KITTITAS COUNTY

DEPARTMENT OF PUBLIC WORKS

County Survey review of Niles Boundary Line Adjustment BL-16-00015

CRUSE & ASSOCIATES
PROFESSIONAL LAND SURVEYORS
217 East Fourth Street P.O. Box 959
Ellensburg, WA 98926 (509) 962-8242
NILES PROPERTY

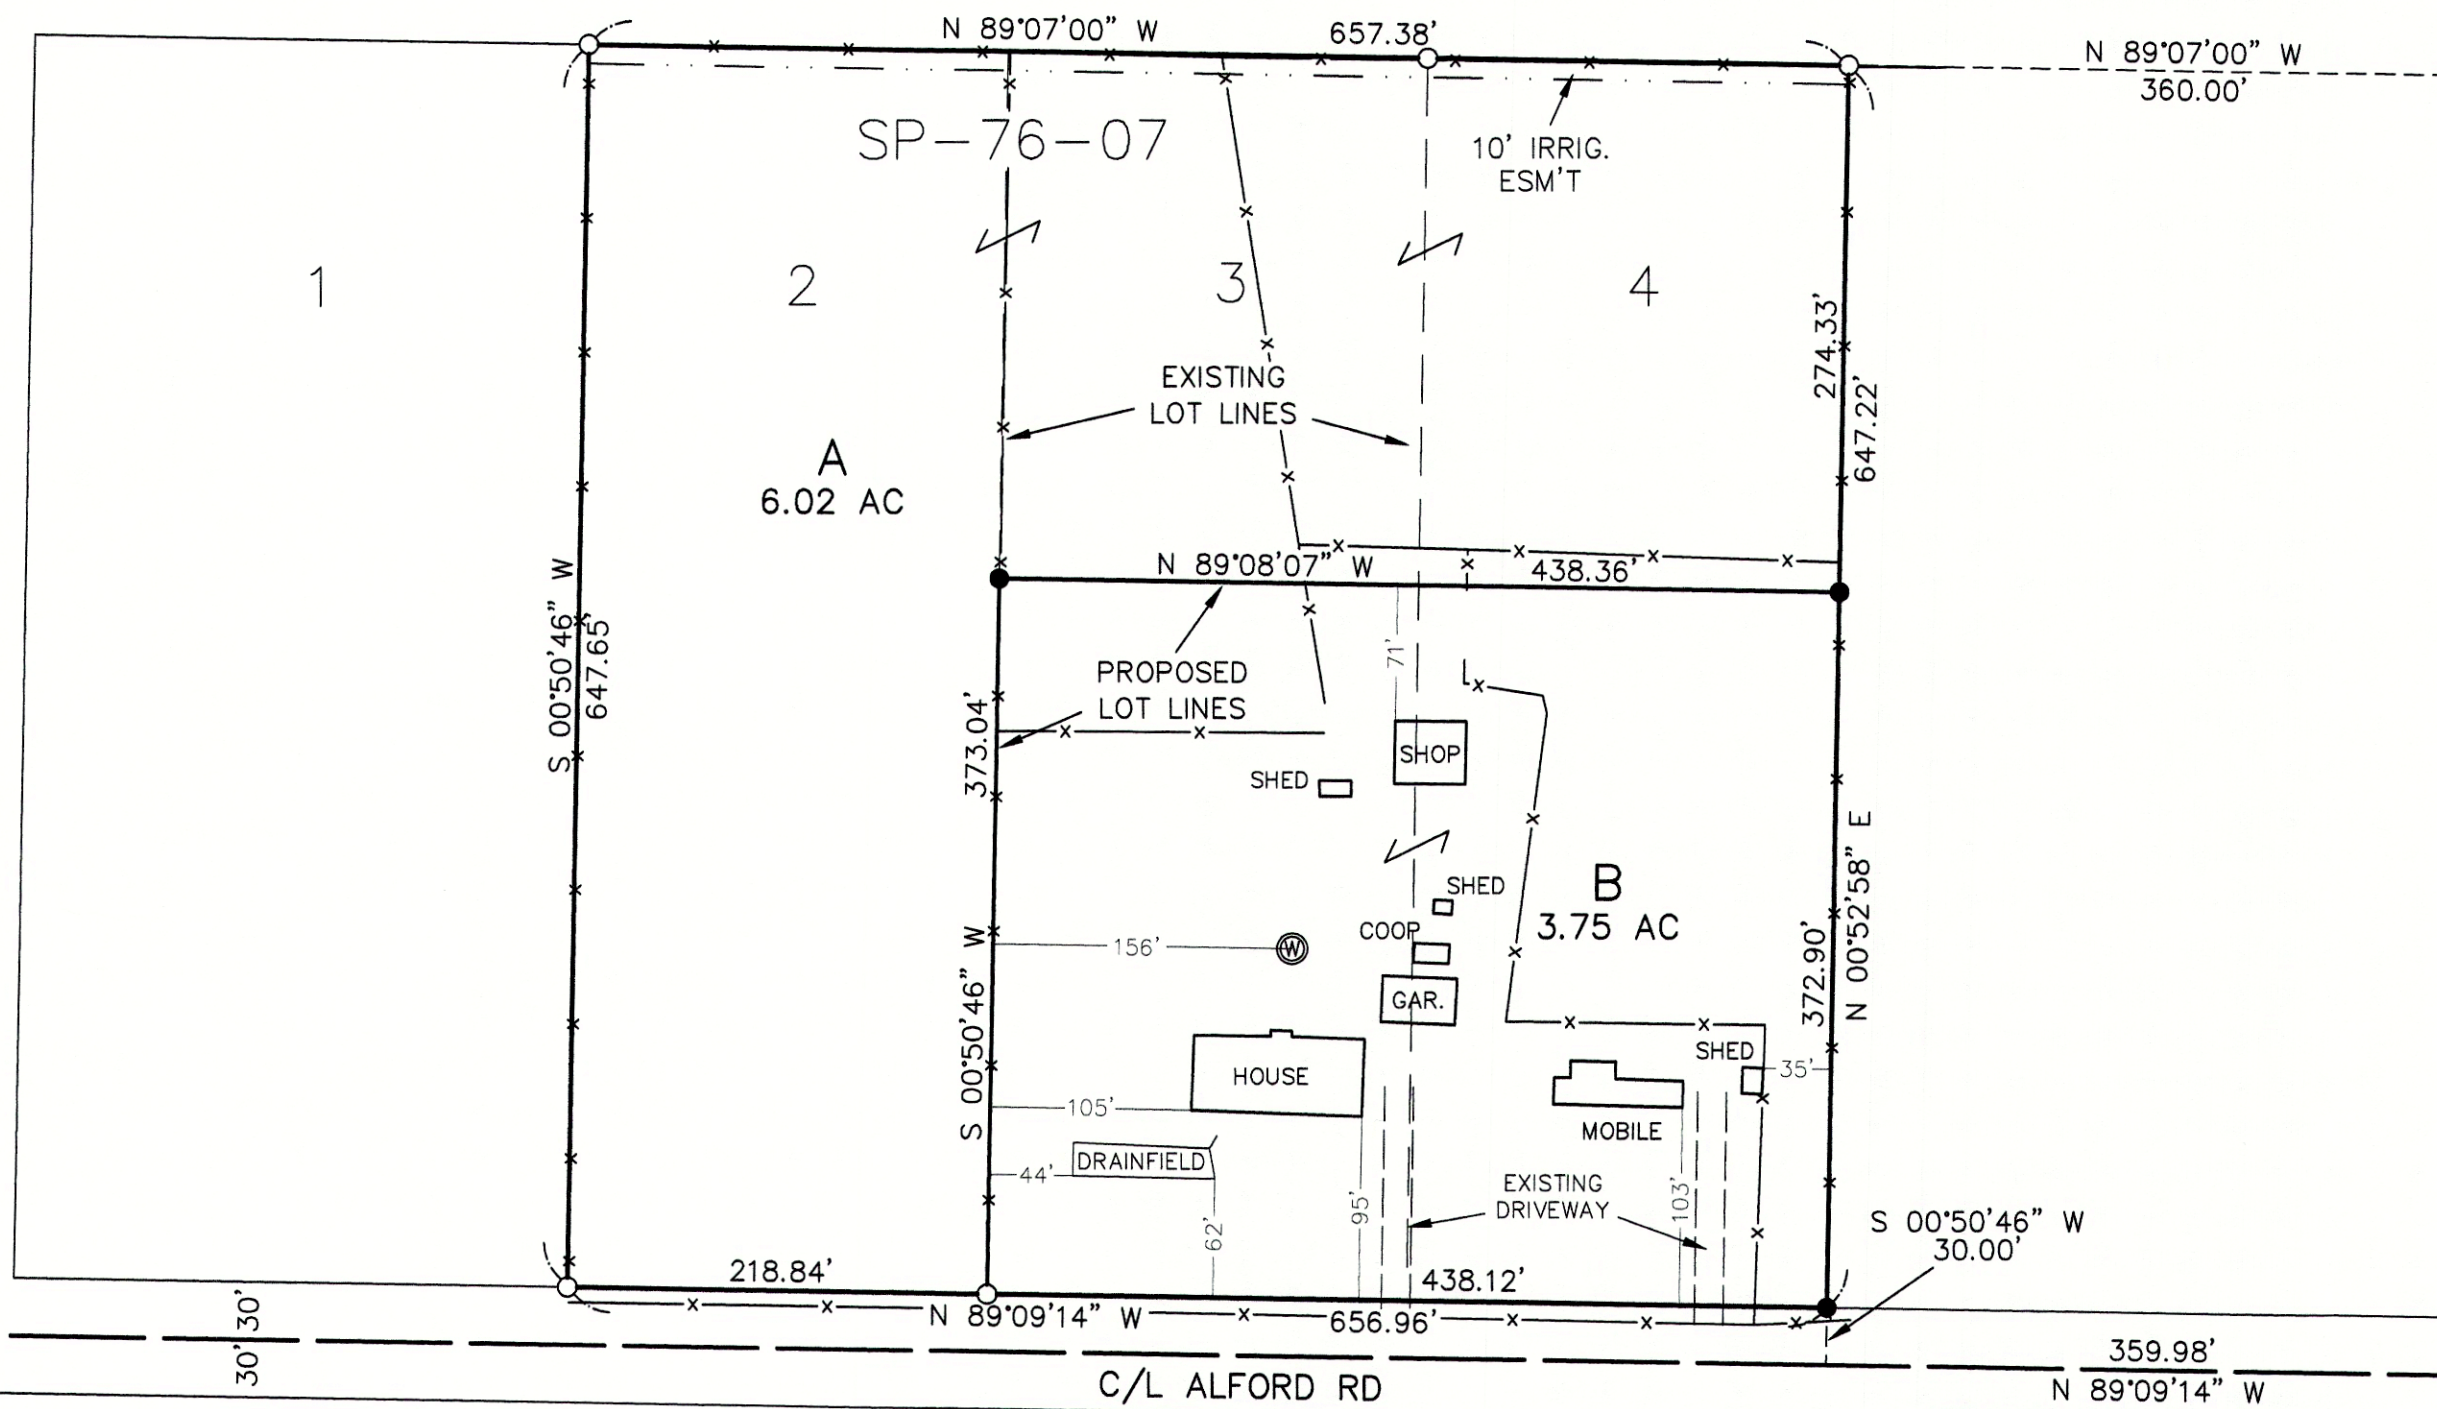
1. The legend referencing found monuments should include the cap details (LS#12491) or if no cap, it should be noted.
2. Replace "10' Irrig. Ease" with "Ex. 10' Irrig. Ease (AFN:408865)" or similar.
3. Label the distance of fence encroachment on Alford Rd R/W, it appears to be about 7-8 feet.
4. Label Wilson Creek Rd and Alford Rd with the name, width, ownership and surfacing material of the roadway (EX. 60' County R/W – Paved)
5. Include the distance ties to the NE and W section corners
